Application no: H19/0275/96

Description: Erection of house and garage

Location: Broadgate Road
Sutton St Edmund
Spalding
Lincs

TOWN AND COUNTRY PLANNING ACT 1990
NOTICE OF ACCEPTANCE OF AMENDMENT

JOB No.	B197 A
DRAWING No.	2 of 3

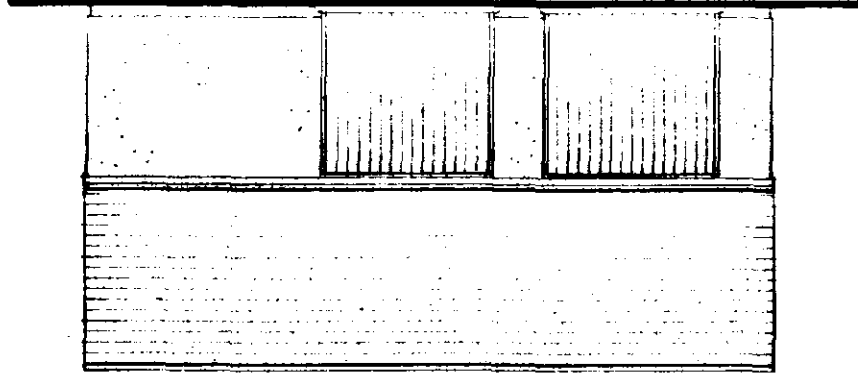
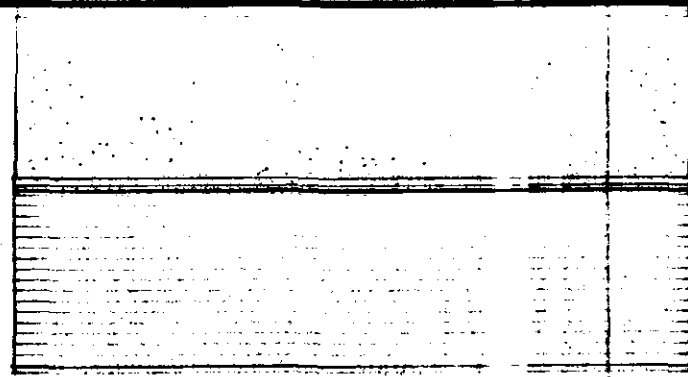
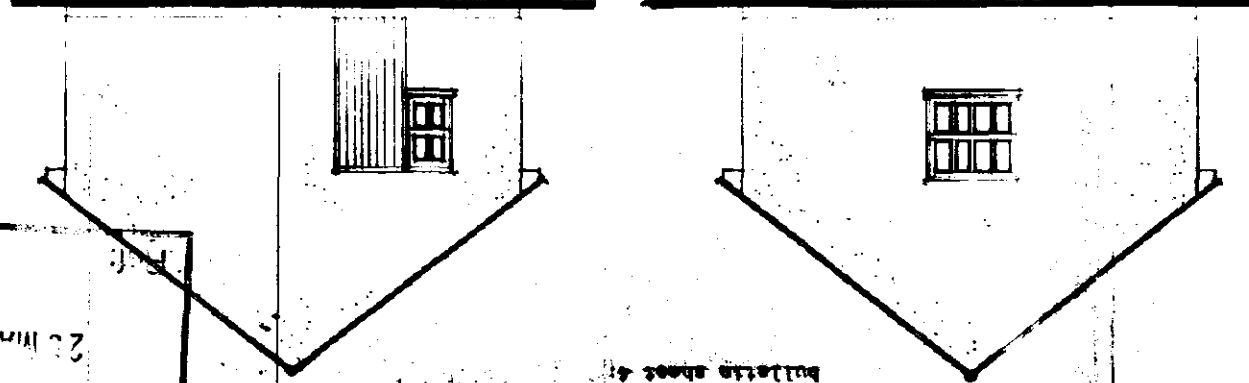
Amendment: Roof tiles changed from blue/black fibre cement slate
to Marley Mendip Brown (Code no. 52)

ROOF TILE CHANGED
FROM:- BLUE/BLACK FIBRE CONCRETE
SLATE TO:- MARLEY MENDIP
BROWN CODE N° 52.

The amended details submitted in respect of the above proposal have now been considered, and I am able to inform you that there are no objections to the amendment being implemented to the extent described above.
